4th January 2022

Town & Country Planning (Control of Advertisement) (England) Regulations 2007 (as amended)

Application No: CM/61/21/A
Site Address: Bairds Farm Shop, Garden Centre Crookthorn Lane Climping BN17 5SN
Description of works: Installation of 1 x externally illuminated fascia sign, 2 x non-illuminated fascia signs, 1 x internally illuminated menu drive through sign to south boundary, 2 x A boards and 2 x roadside flags.

Proposed Front EAST Elevation
Scale: 1:50

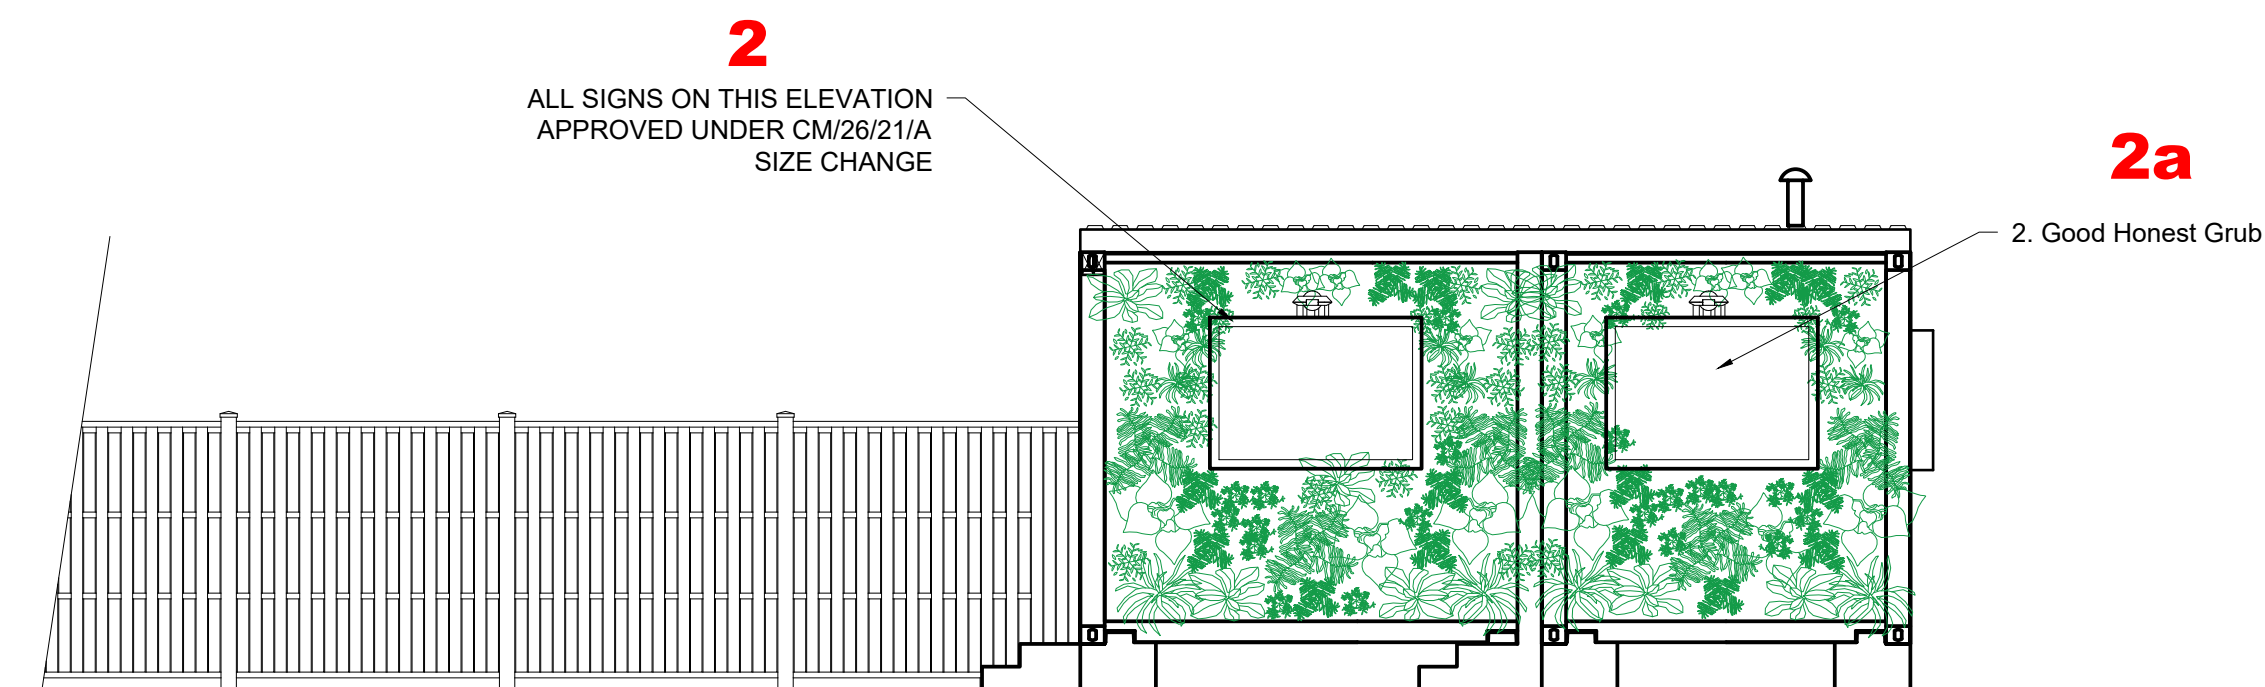
The planning officer's decision stated that 4 signs being illuminated would be excessive for the area. The menu and proposed logo should only be illuminated during the opening hours of Baird's Farm Shop (now Maidenhead Aquatics) and the two signs on the side elevation would not be acceptable. The recommended

illumination for the site area would be 400cd/m2, not the proposed 1200cd/m2 as this would not be acceptable for the location which falls under category zone E2 of the WSCC illuminated signs standard advice.

The Bald Kitchen agreed to these conditions but then blatantly ignored them and all the fascia boards (front and side) on the Bald Kitchen shipping container were at high illumination. An enforcement notice was subsequently issued ENF/245/21

Proposed Logo - Sign 1 Luminated Sign
Scale: 1:20

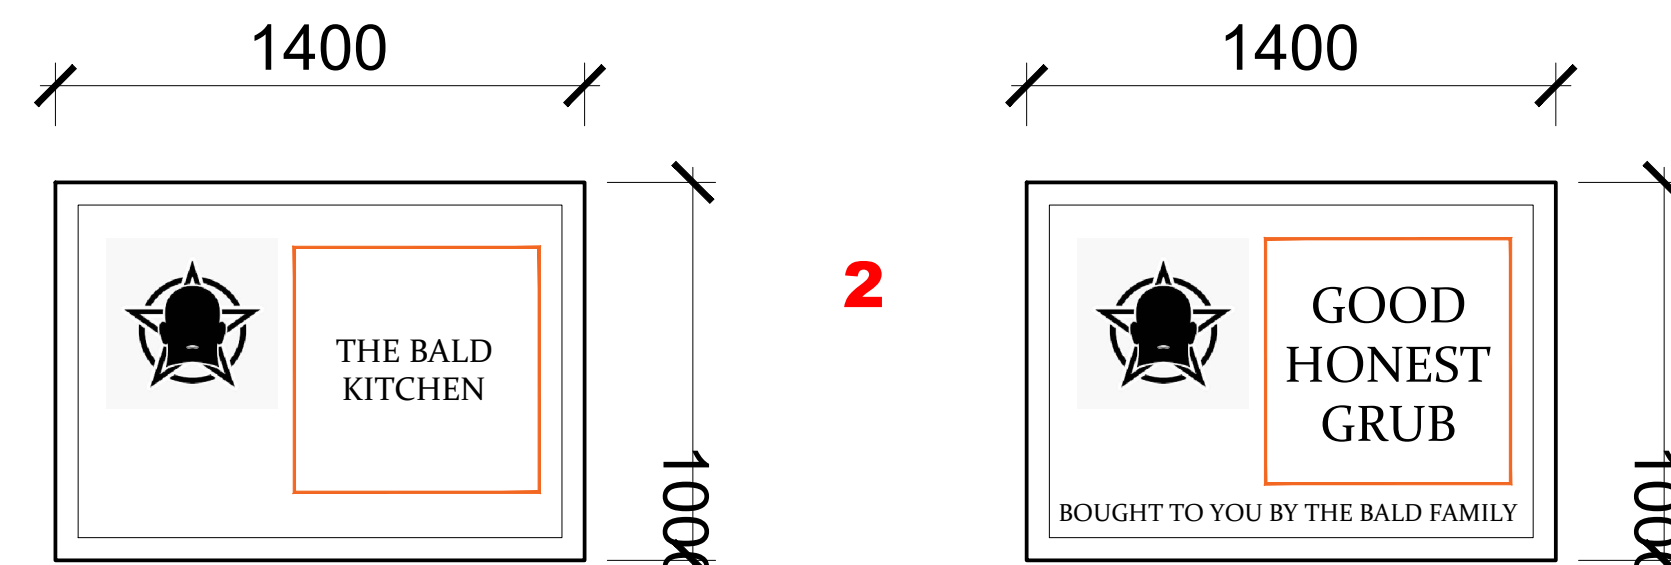
Please note that they have asked for the advertising signs to be illuminated at 600cd/m2, still higher than that recommended in the WSCC illuminated signs standard advice and by Arun District Council. They are asking for the illumination to be for the opening hours of the Bald Kitchen (from 6am Monday-Friday and 7am Saturday) which are far longer hours than Maidenhead Aquatics is open or Bairds Farm Shop was open. This is not an industrial park or an urban area. This site is a farm building in a rural area.

Flag to go road side
Scale: 1:20

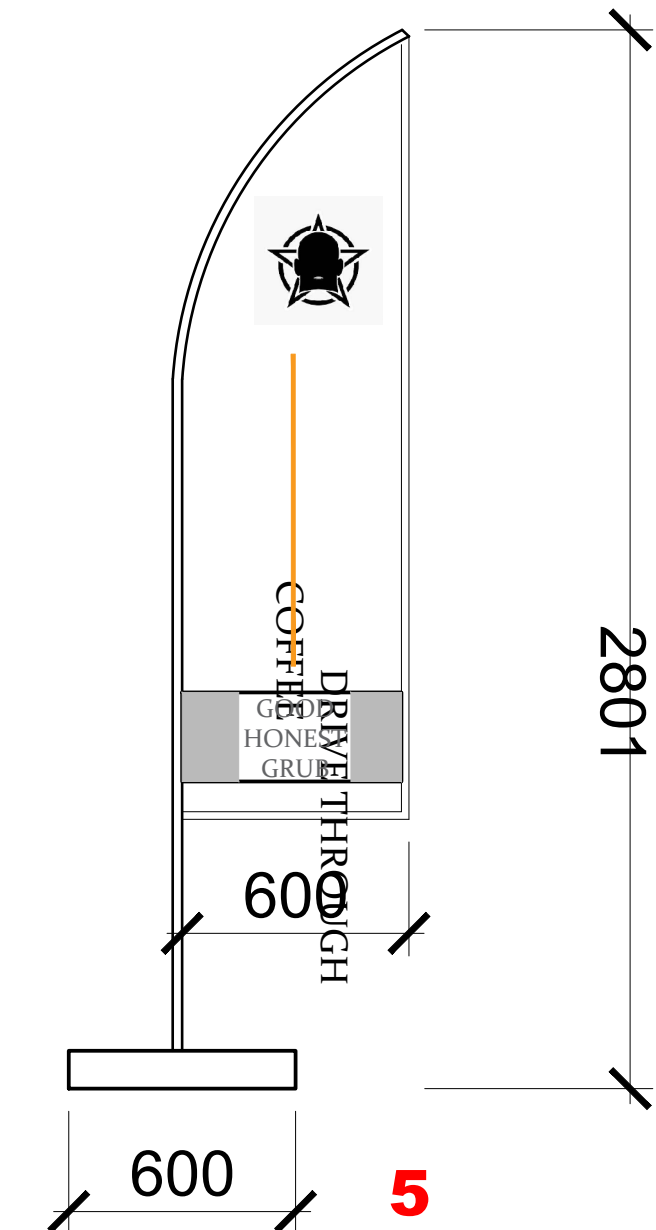
The addition of two illuminated framed flags (frame illuminated but not the flag?) on each side of the entrance to the site will confuse and distract drivers on the A259 and would be a traffic hazard.

3. Proposed Side SOUTH Boundary of drive through sign - Illuminated

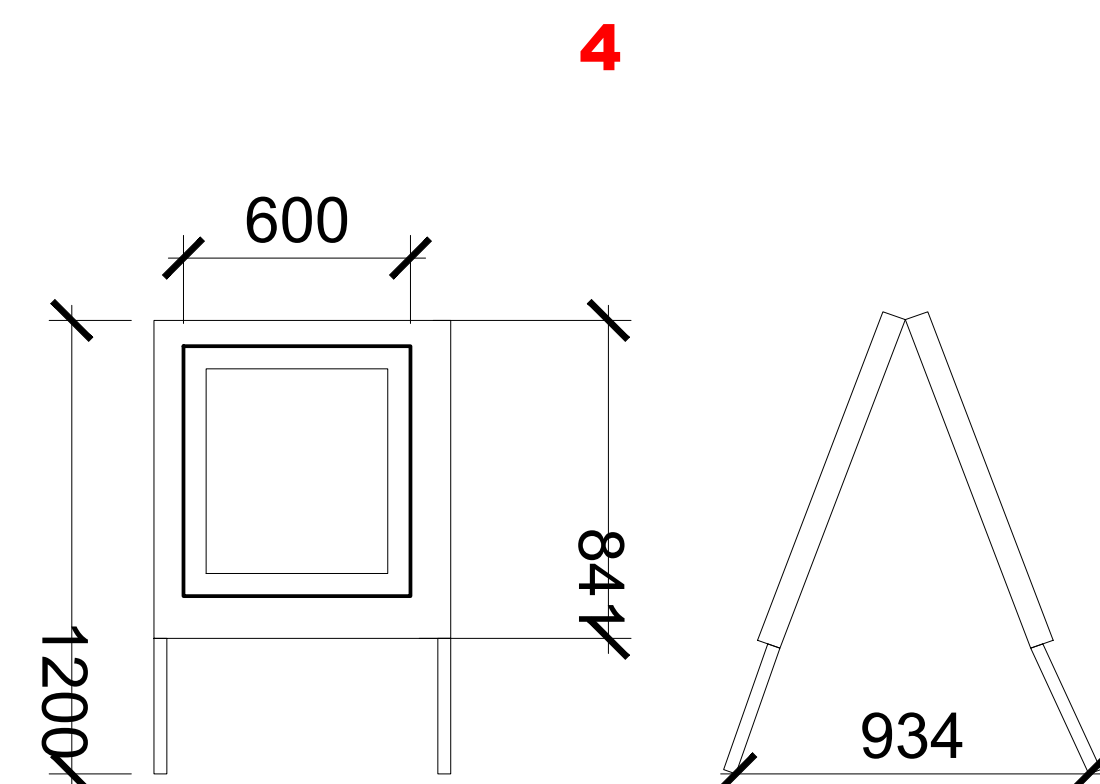
There is a listed building within 28m of the site. The screening of a 6ft fence is totally inadequate and the residents of The Cottage would be subject to light pollution from 6am.
